**APPLICATION BY AQUIND LIMITED FOR AN ORDER GRANTING DEVELOPMENT
CONSENT FOR THE AQUIND INTERCONNECTOR PROJECT**

APPLICATION REF: EN020022

**WRITTEN REPRESENTATION OF THE HISTORIC BUILDINGS AND MONUMENTS
COMMISSION FOR ENGLAND (HISTORIC ENGLAND)**

DRAWING No: EN020022-2.10-EL-Sheet1	REV: 01
-------------------------------------	---------

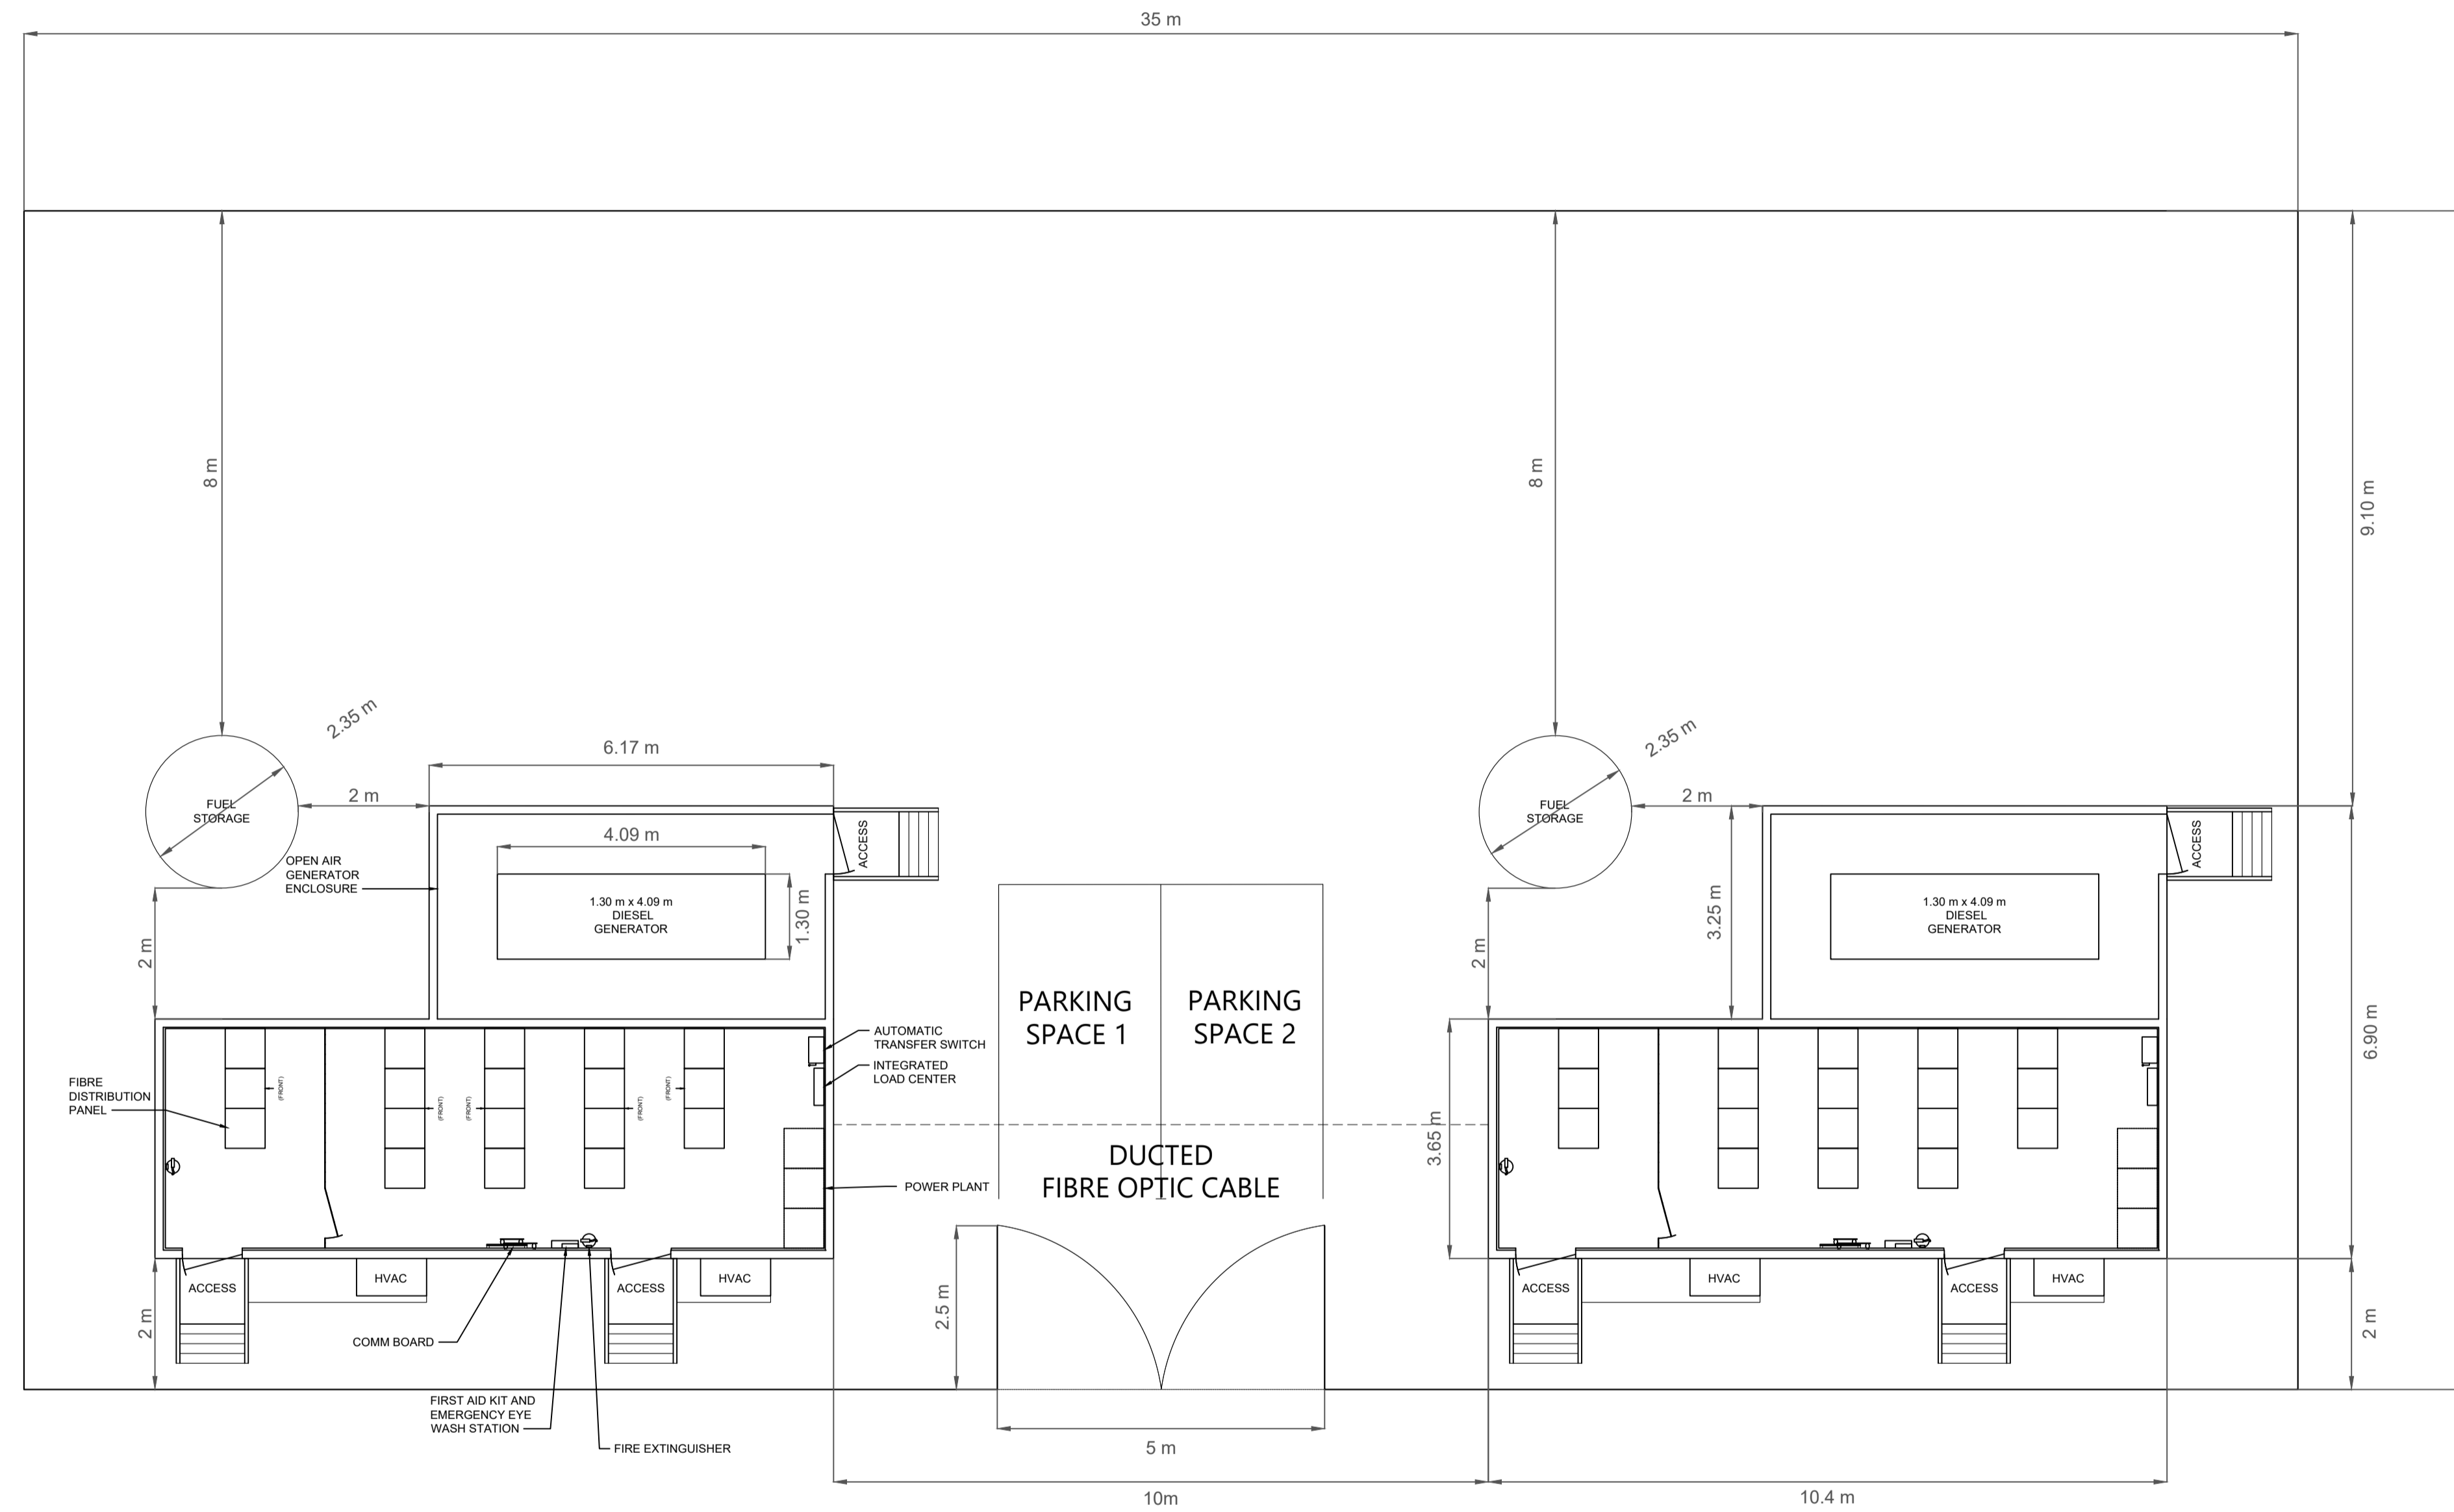
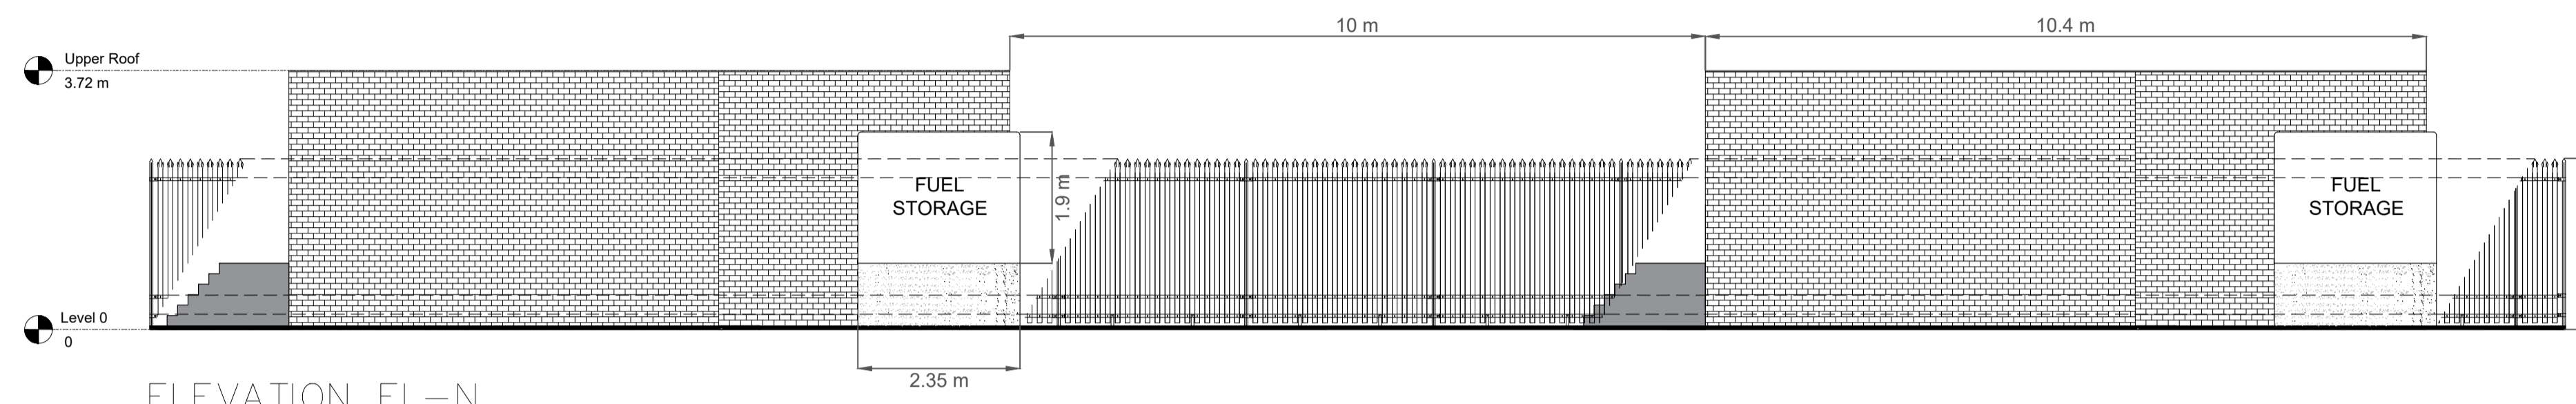
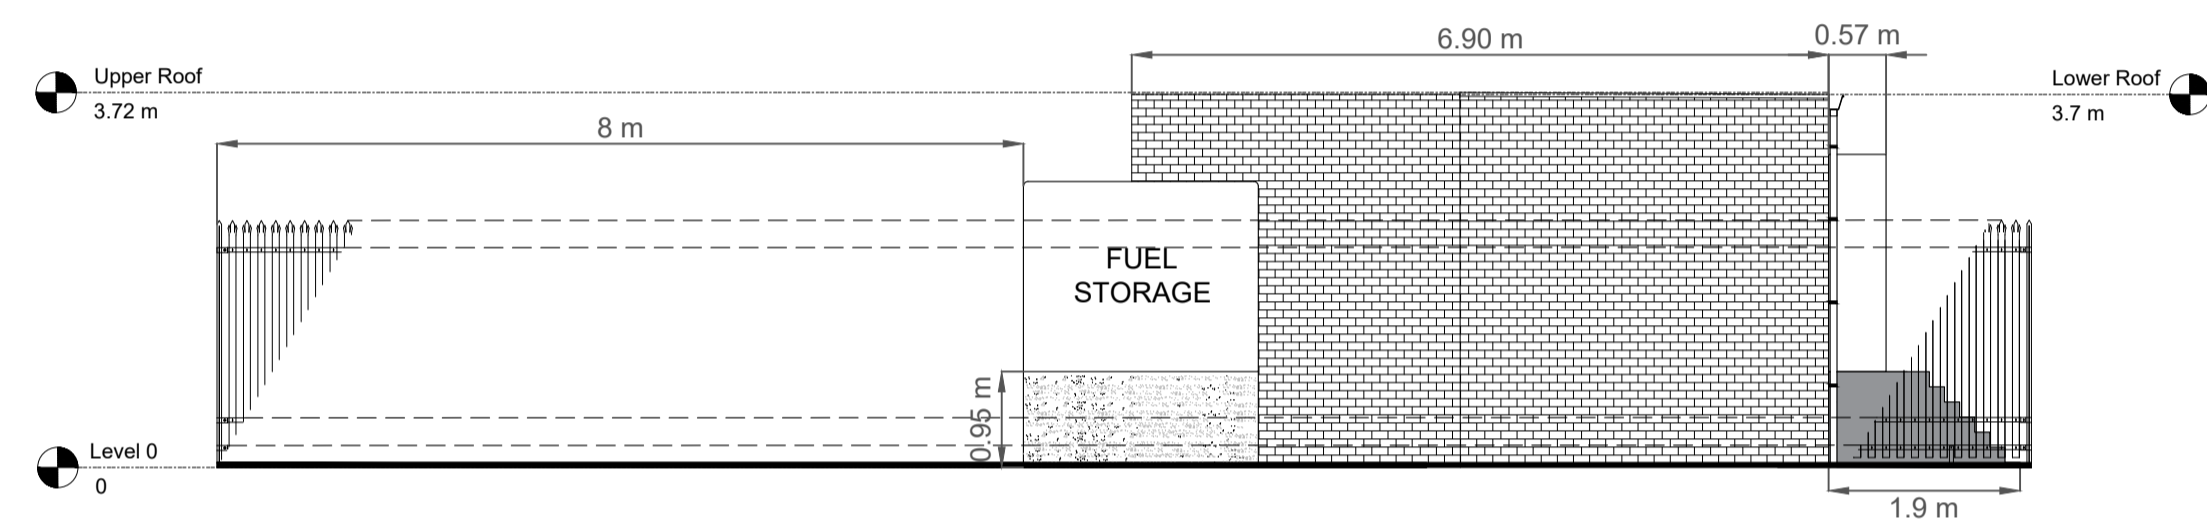
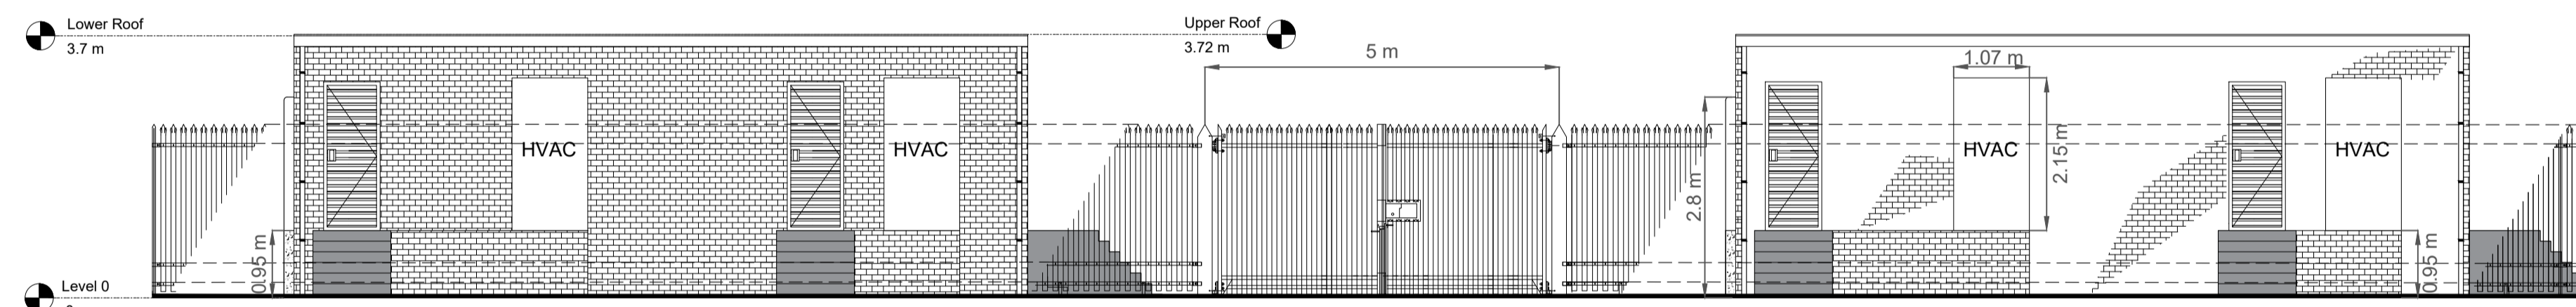
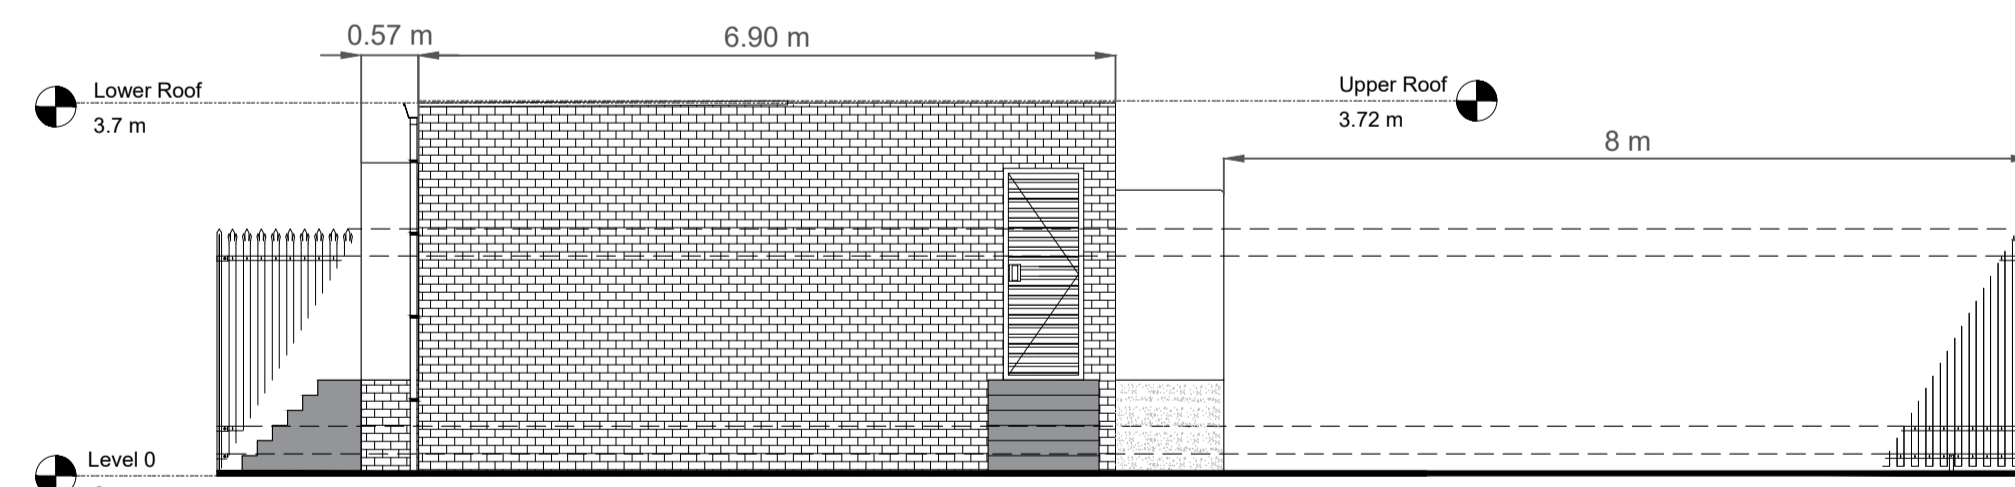
- 4.8 We note from the documents submitted (specifically the Indicative ORS Elevations and Floor Plans and Parameter Plans– Document Refs: 2.10 & 2.11 respectively), that the ORS is comprised of two structures along the north-western boundary of the car park, located west of Fort Cumberland. As noted in paragraph 21.6.4.28 (ES Chapter 21), this area of land which was previously used for military rifle ranges and the car park is in the historic field of fire (note typo in text) from the western ravelin of the fort, which was designed to defend against attack from land. For the

proposed project, we note that each building would measure 10m x 4m with a proposed height of 4m at a distance of around 250m from the glacis of the Fort. The buildings would be fenced off and surrounded by native hedgerow/trees and amenity grassland (Figure 15.50 – Indicative Landscape Mitigation Plan).

- 4.9 The assessment of Predicted Operational Stage Environmental Effects in Table 2 (Appendix 21.4) notes that the flat nature of the present car park allows for the preservation of views from the ravelin towards Fort Cumberland Road. It goes on to state that as the ORS will be based in the north-east corner of the car park, and due to its proposed height, the majority of the flat landscape will be retained. Figures 15.55 (Viewpoint 21) and 15.56 (Viewpoint 22) provide an indication of the view of the proposed location of the ORS as would be experienced from the direction of the Fort, but not from within the Fort itself or, in particular from the ravelin. As such it has not been demonstrated that the view of the approach road to the Fort will not be impacted by the new building, thus impacting the understanding and appreciation of the relationship between them.

- 4.10 Since the ES was produced in November 2019, we have engaged in discussions with the applicant's heritage consultant about the impact of the proposed ORS on the view from the ravelin to Fort Cumberland Road. These discussions are ongoing, but it is understood that a new visualisation will be submitted which will more effectively demonstrate the potential impact (or not) of the proposed siting of the ORS within the car park on the setting of the Fort. At the time of this submission, the new visual has not yet been submitted by the Applicant. Discussions are also ongoing concerning the colour and materials palette for the new building and with regard to the screening options.
